EIAR Addendum

Appendix 16-B Navigational
Risk Assessment Addendum

Codling Wind Park Limited (CWPL) is proposing to develop the Codling Wind Park (CWP) Project, which is located in the Irish Sea approximately 13 - 22 km off the east coast of Ireland, at County Wicklow.

This document has been prepared in response to Item 2 of the Commission's FIR. It forms an addendum to Volume 4, Appendix 16.3 Navigational Risk Assessment of the EIAR and supports Section 16 of EIAR Addendum (Part 2). Explanatory notes throughout the sections of the addendum highlight where new and / or revised information has been provided for consideration by the Commission in conjunction with the information provided within the original document. The explanatory notes also refer back to this document to confirm how the new and / or revised information relates to the requests made within the Commission's FIR.

Export Cable Installation at Zone of Greater Burial Depth
Scale 1:50

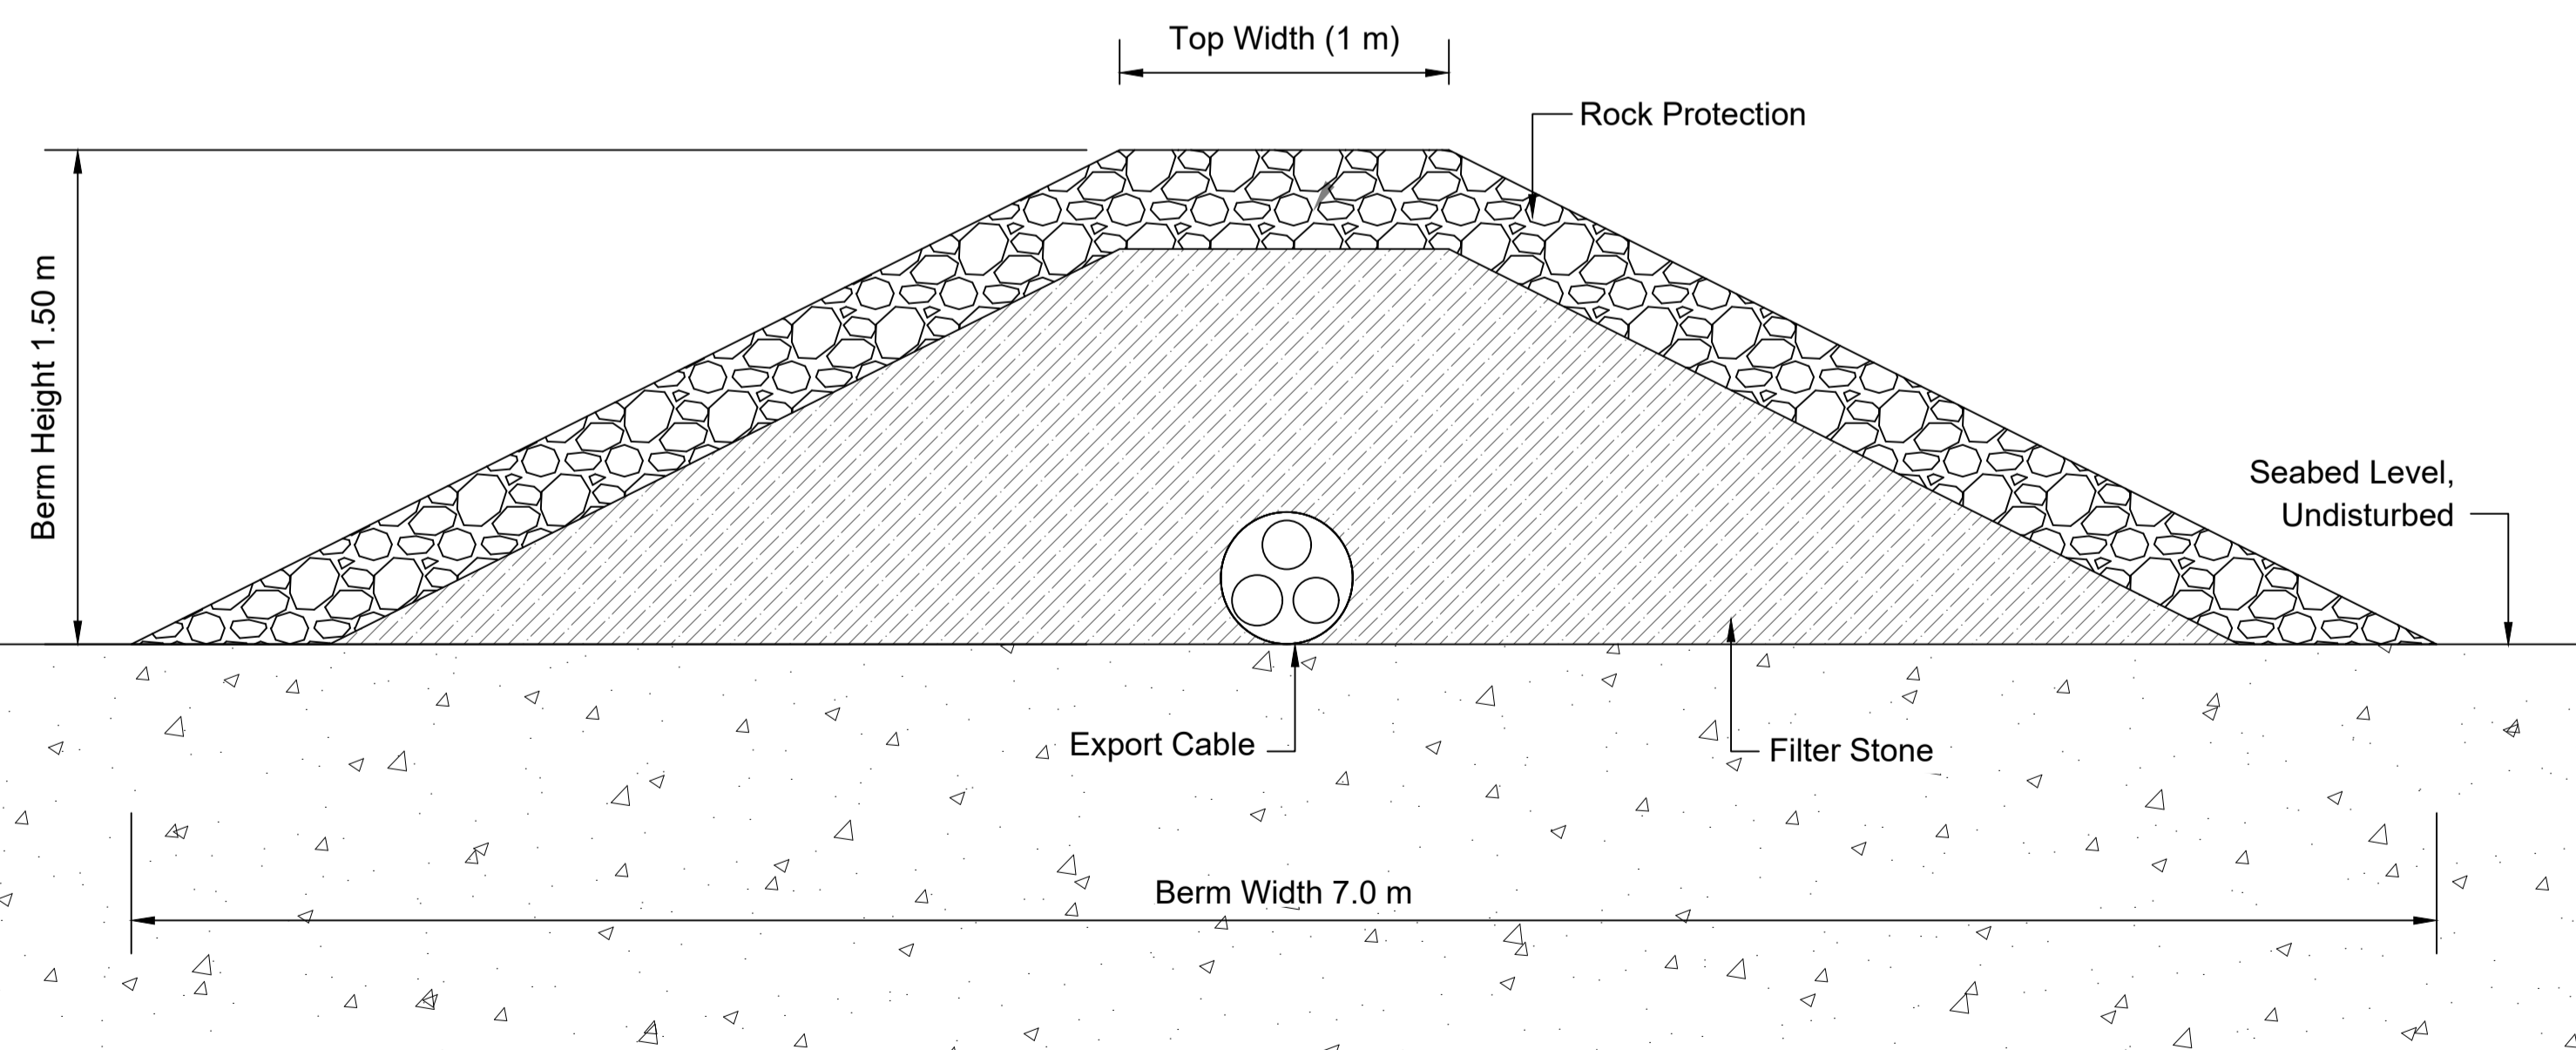
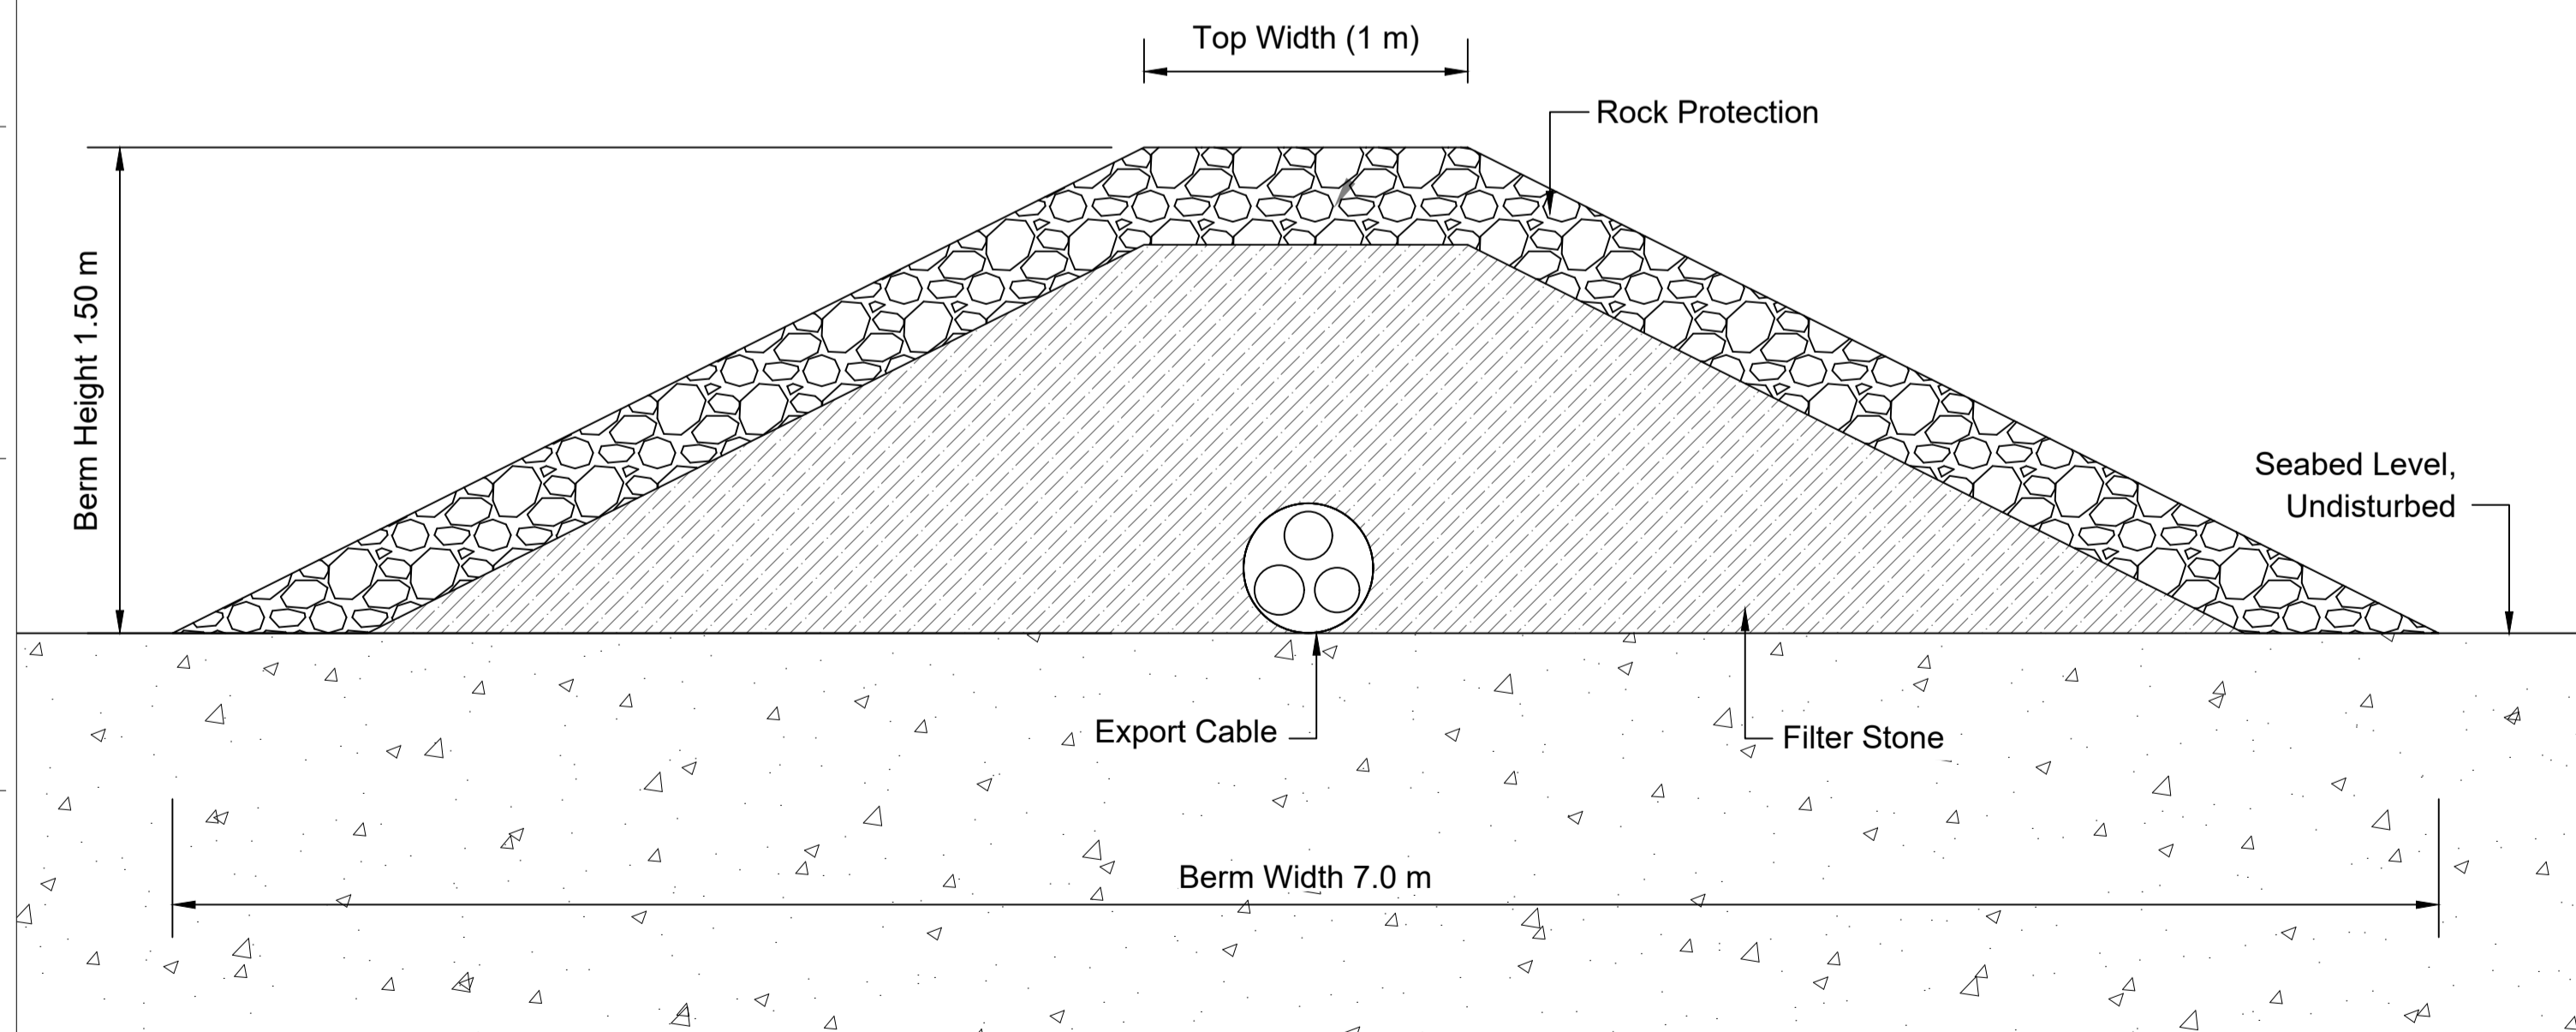
Section 16.1 is unchanged except for Table 16-1, which now includes the following rows provided in **Table 16-A** below. This update has been made in response to FIR Items 2a and 2b. **Table 16-A** has also been updated to clarify that the value of the minimum depth of cover (export cables) (metres (m)) representative scenario is 3.0m within the zone of greater burial depth adjacent to Dún Laoghaire Harbour.
